KIRKLEES METROPOLITAN COUNCIL INVESTMENT & REGENERATION SERVICE

DELEGATED DECISION TO DETERMINE APPLICATIONS FOR LISTED BUILDING CONSENT

Reference No:	2023/65/90043/W
Site Address:	The Farmhouse, Carr Farm, Uppergate, Hepworth, Holmfirth, HD9 1TG
Description:	Listed Building Consent for erection of single storey extension with associated works and solar panels (Listed Building within a Conservation Area)
Recommending Officer:	William Simcock

Officer Report – The Farmhouse, Carr Farm, Hepworth 2023/90043 – Listed Building Consent

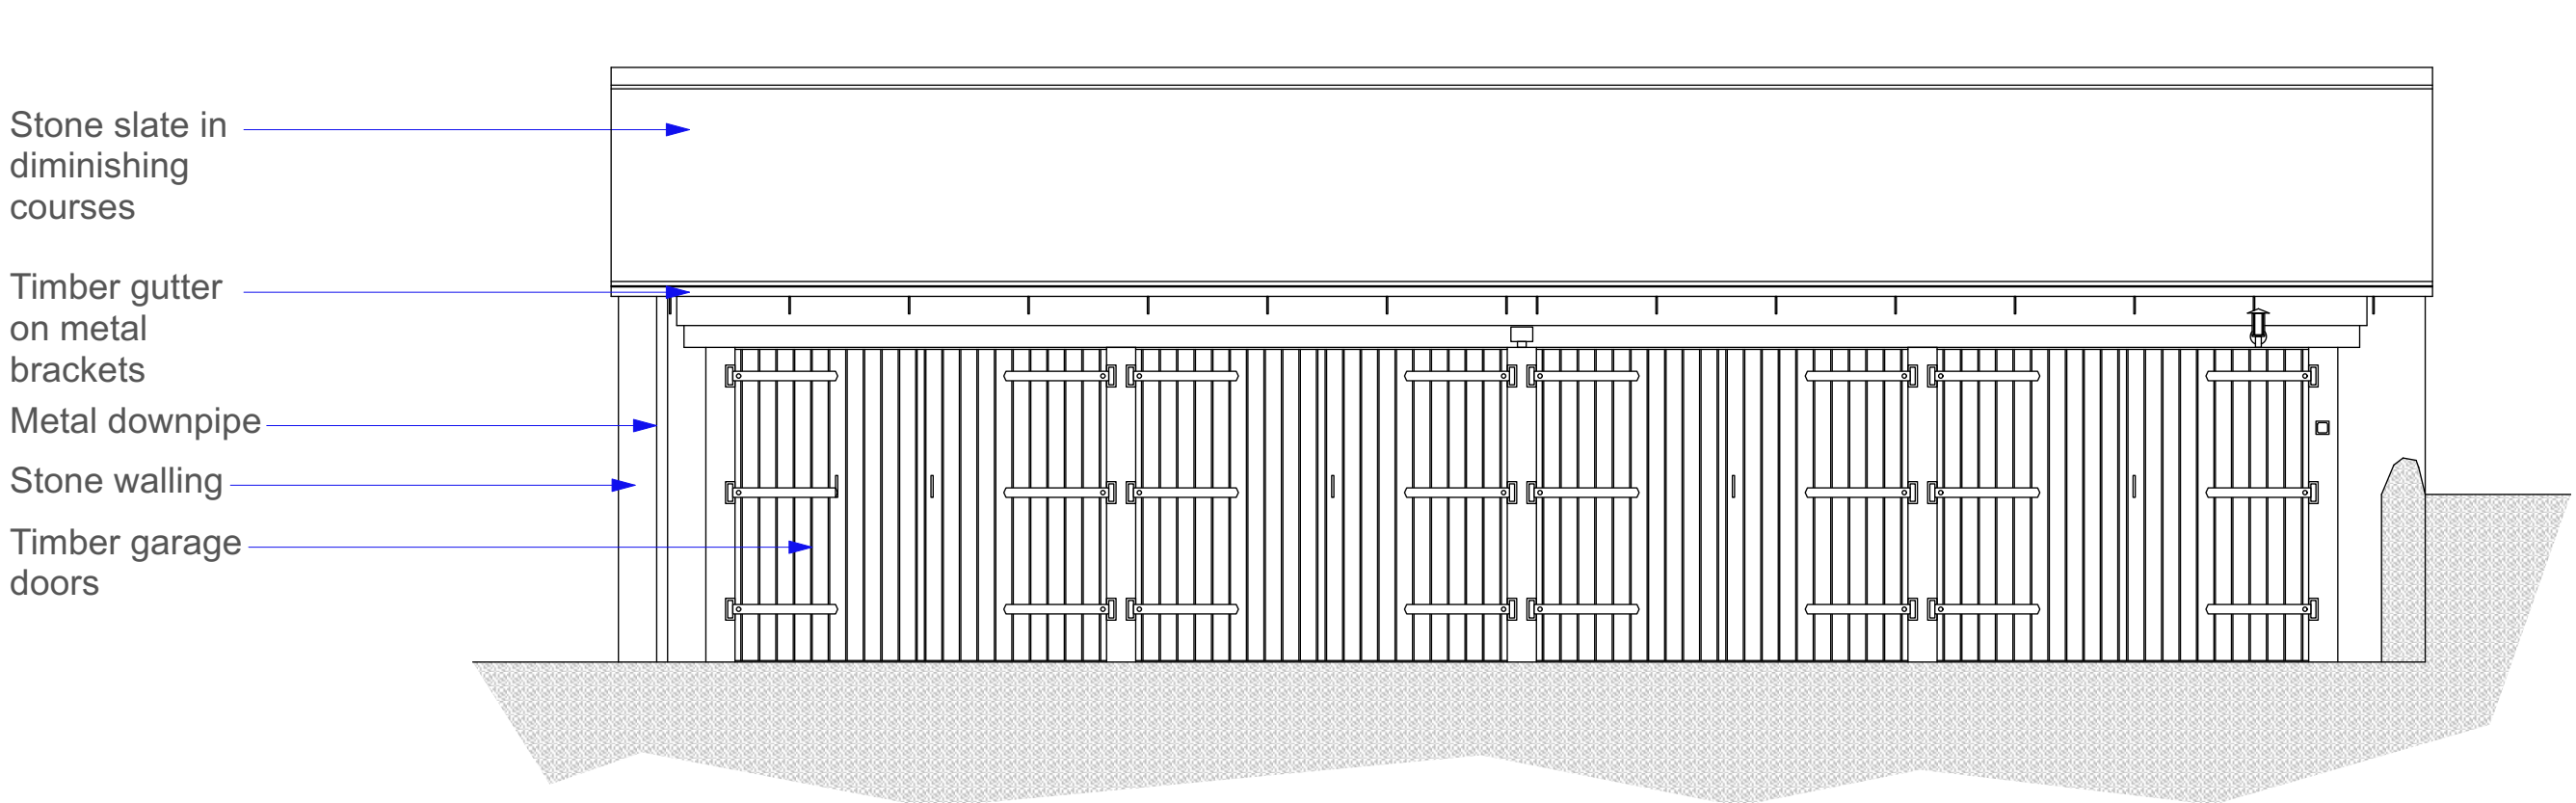
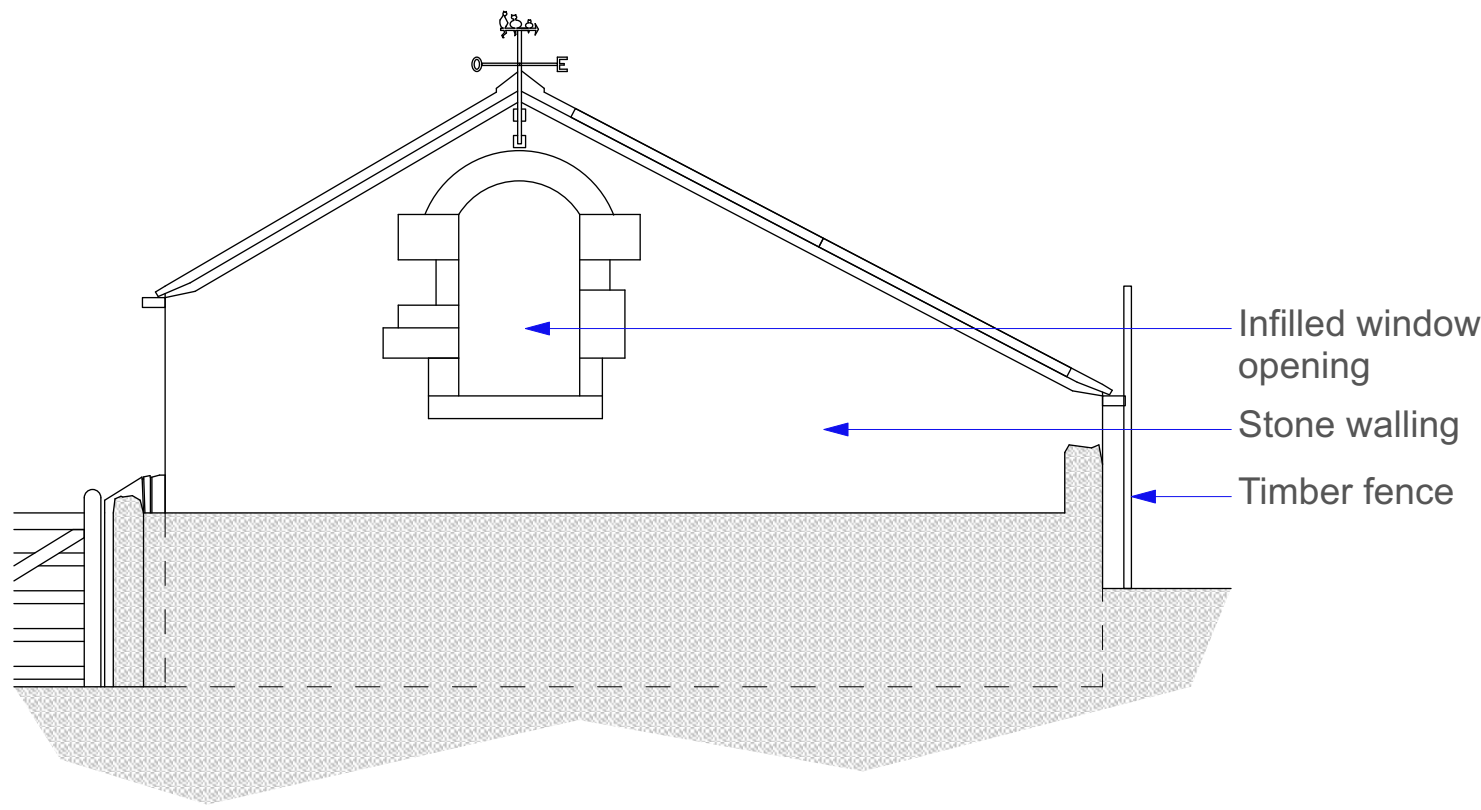
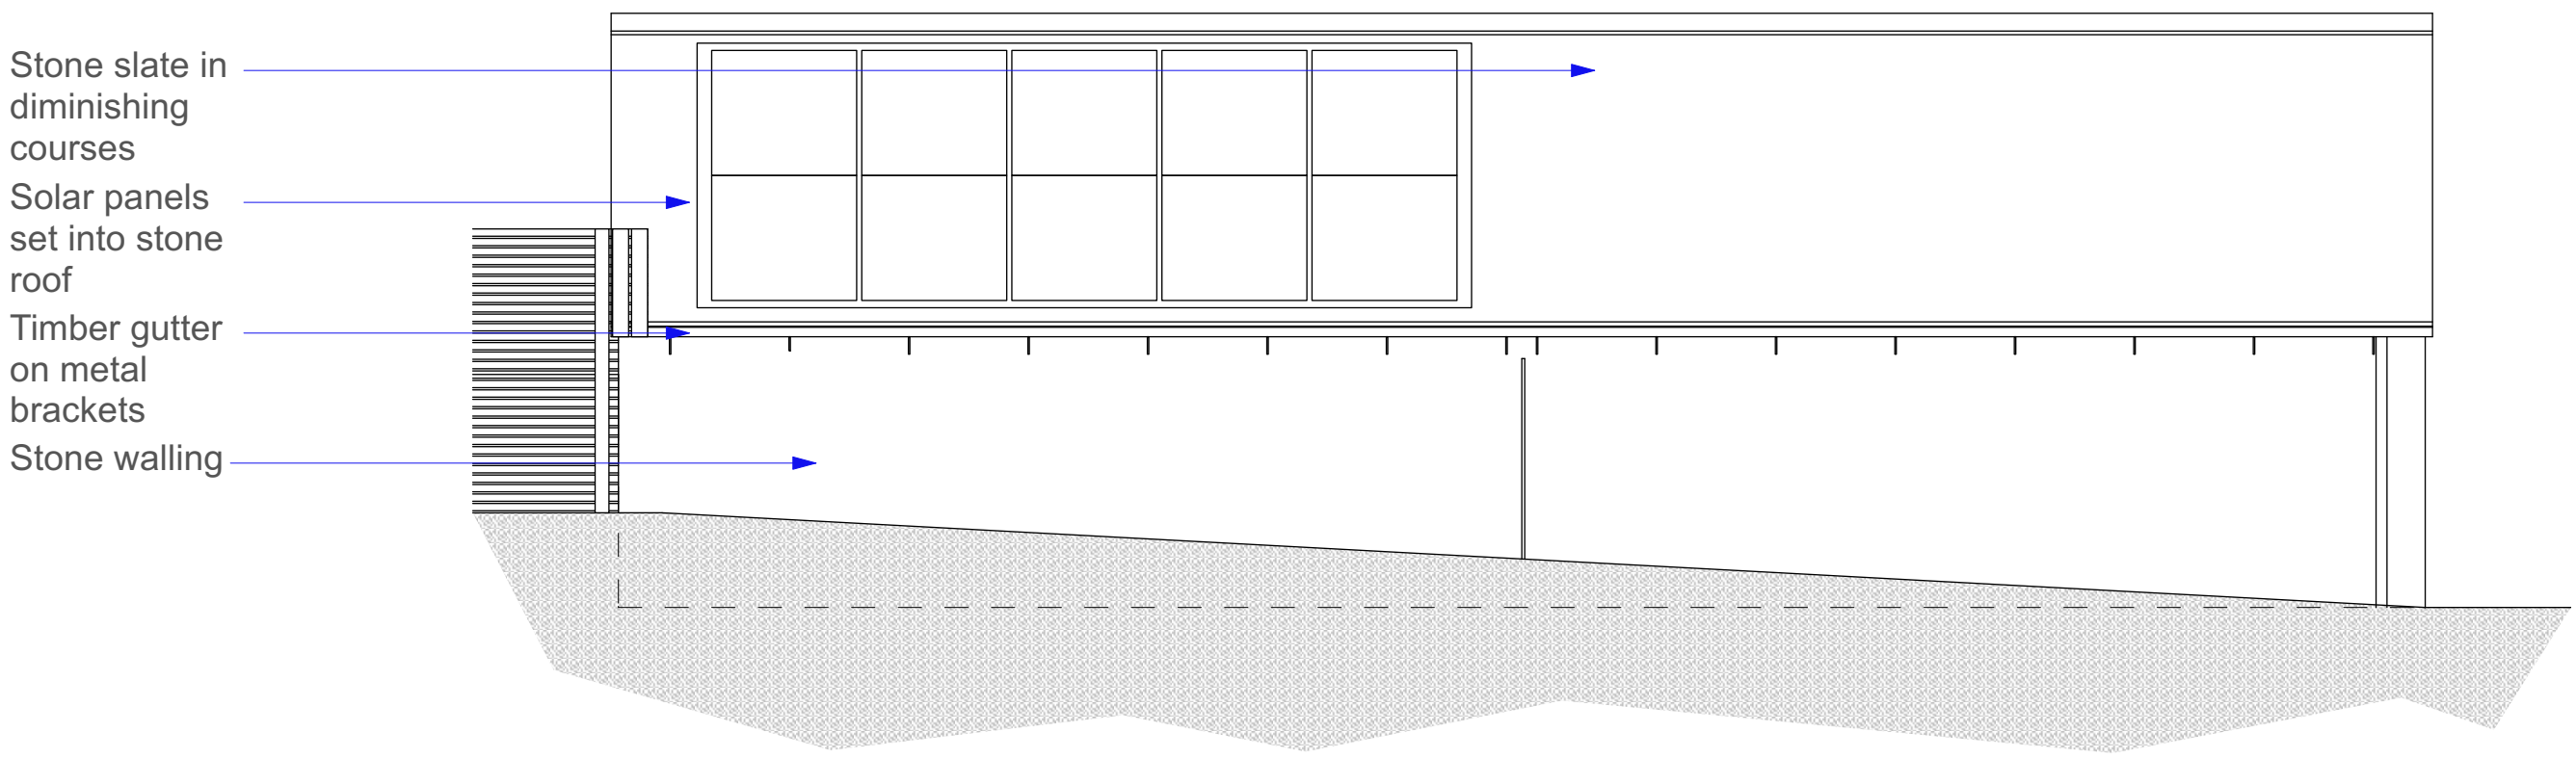
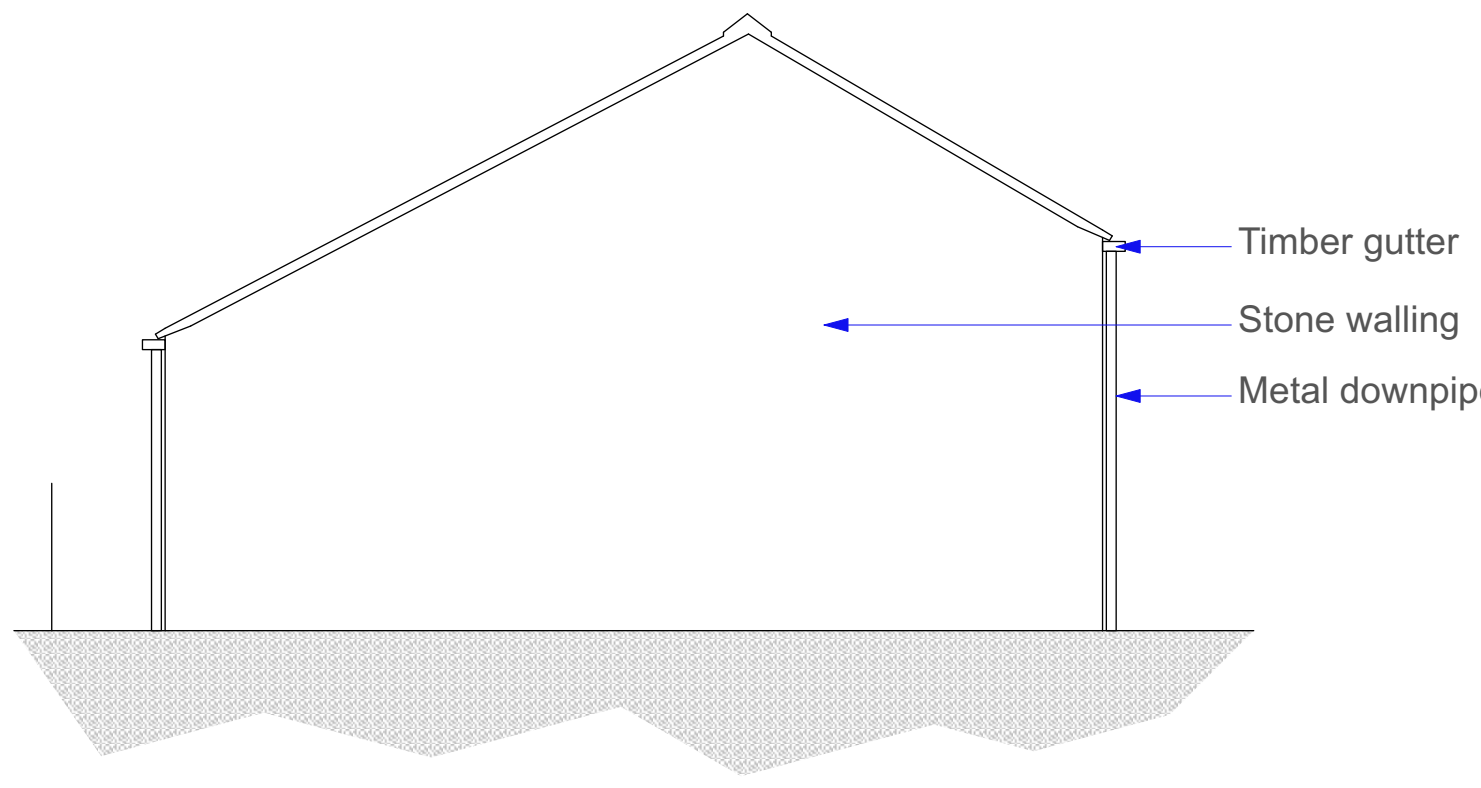
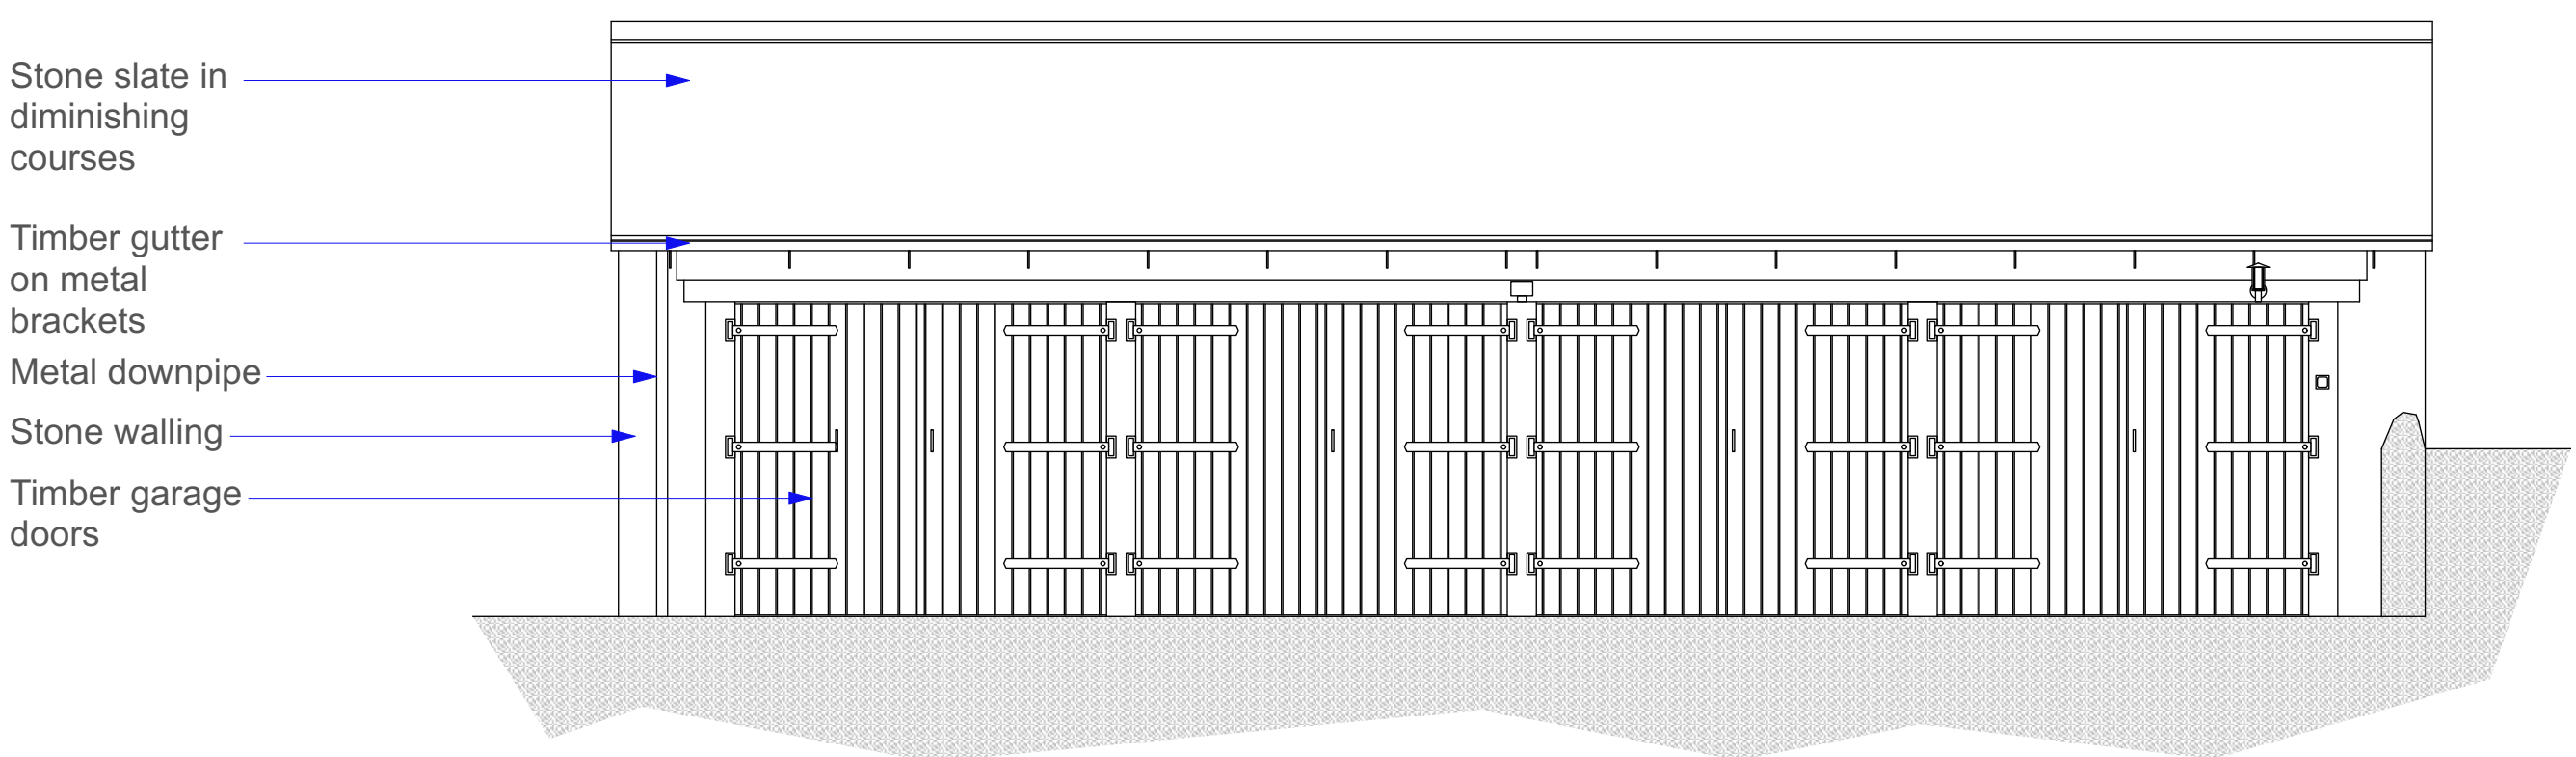
KC Conservation & Design – Originally requested the solar panels to be reduced in numbers and moved towards the centre of the garage roof. Final comments, made informally and received 11th December, are that the proposal can be accepted without any further alteration. Earlier comments dated 30th November provide a full list of recommended conditions for the works to the Farmhouse.

It is noted that the outbuilding is not expressly Listed although it is Listed by association, by reason of being an original curtilage building. The solar panels would be a modern feature but they would be a reversible change and it is considered that the impact on the significance of the Listed Building would be minimal.
